Application No: FG/34/21/HH
Site Address: 50 Ocean Drive Ferring BN12 5QP
Description of works: 1st floor side extensions, two storey front extension, side and rear extensions, installation of balcony to rear and 2 x front dormers including demolition of existing garage.

Thank you for your internet representation made on 8th April 2021 which has been recorded as an objection with the comments as follows:

SIDE (n)

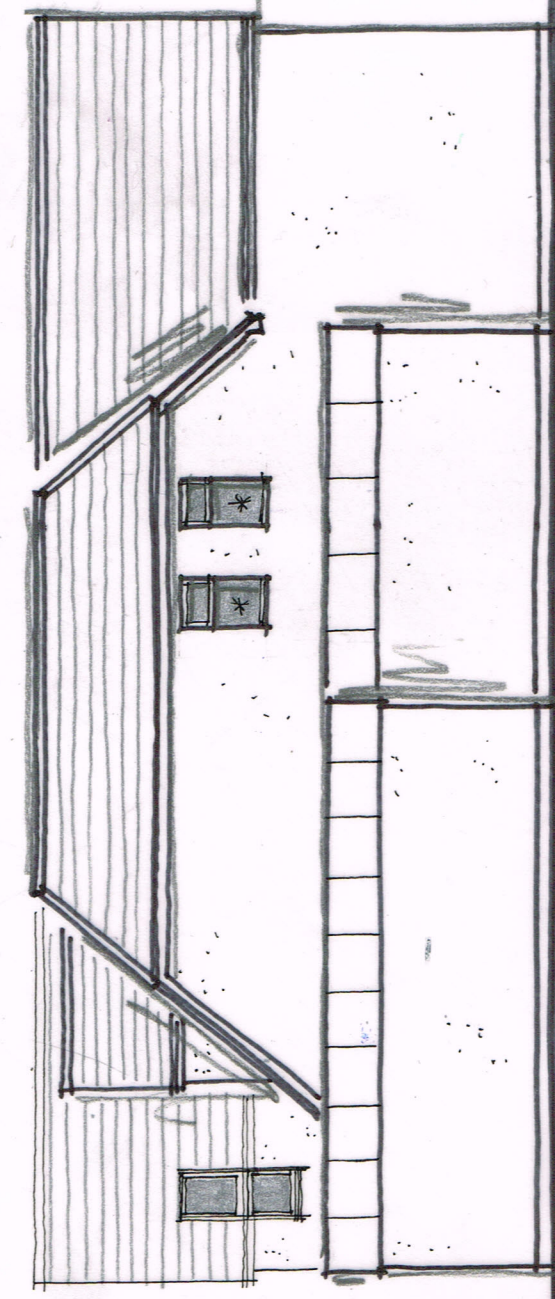
3) The Arun Design Guide (January 2021) makes specifications for extensions. The proposals appear to ignore the 25-degree test and the 45-degree line and as such have significant impact on my property. The design statement implies that the rear two storey north extension is along the side of 44A. It is in fact 5m from the rear of 44A as the windows of the principal bedroom, kitchen and sitting room which form the rear of 44A all face south along the boundary with the proposed development. I calculate loss of direct sunlight to my

main bedroom and kitchen to a significant degree in summer between the equinoxes, and totally during the winter months October to March. I will wake up and look out of my bedroom to a large blank wall, with a massive reduction of access to light (and sun as mentioned above). From my kitchen, especially the sink where I spend considerable time, I will face the high north facing 2 storey wall and roof, with significant loss of natural light especially sunlight. The proposed window and Juliet railing of bedroom two have direct vision into my sitting room and my garden at the rear (south facing) and a significant part of the side of my property (west facing) - a gross loss of privacy. Because the floor of the current 50 Ocean Drive is at least 30 if not 40 cm above the rear garden, anyone of average height looking out of the proposed rear doors in the breakfast area under bedroom 2 will see over the fence and directly into my sitting room whose window is close by. The rear elevation drawing gives the impression of a significant distance from my boundary, by marking the boundary at the side store - but my boundary also forms the north wall of that 2-storey extension which is planned to project rearward beyond the store for 4 metres. There is no detail of the height of the single storey extension along my boundary either.

REAR (w)

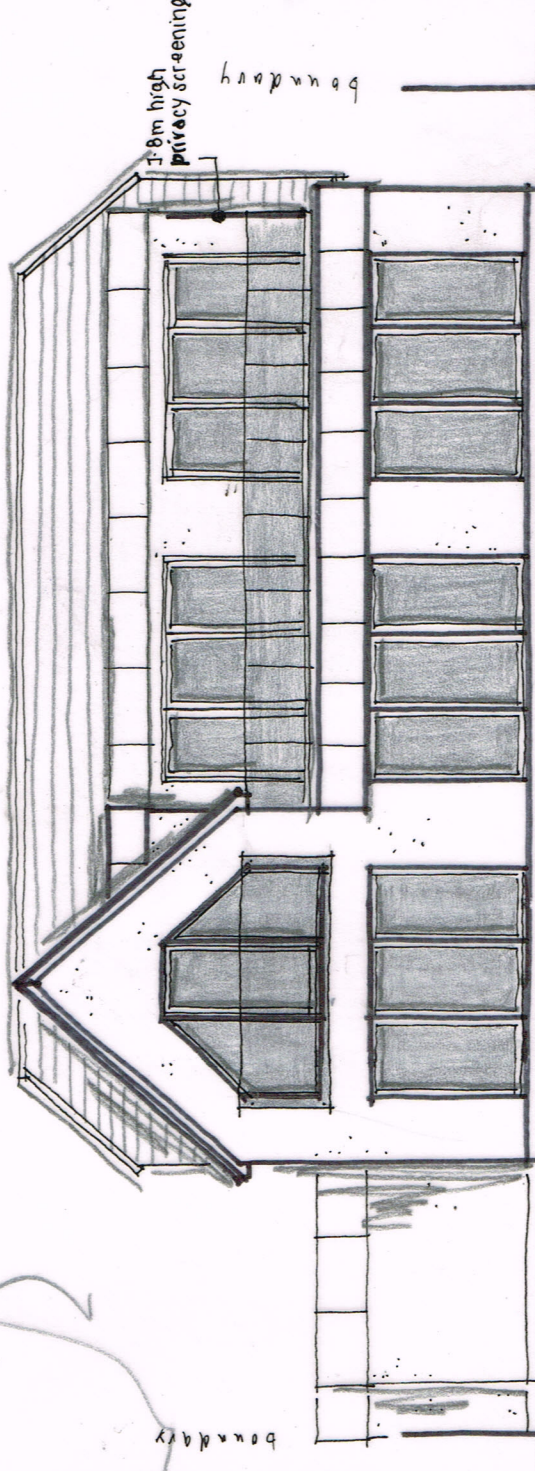
4) The huge first floor balcony destroys privacy of many neighbouring gardens but mine in particular by giving direct views into what has been a private and personal space, showing disrespect to my substantive right for a private life
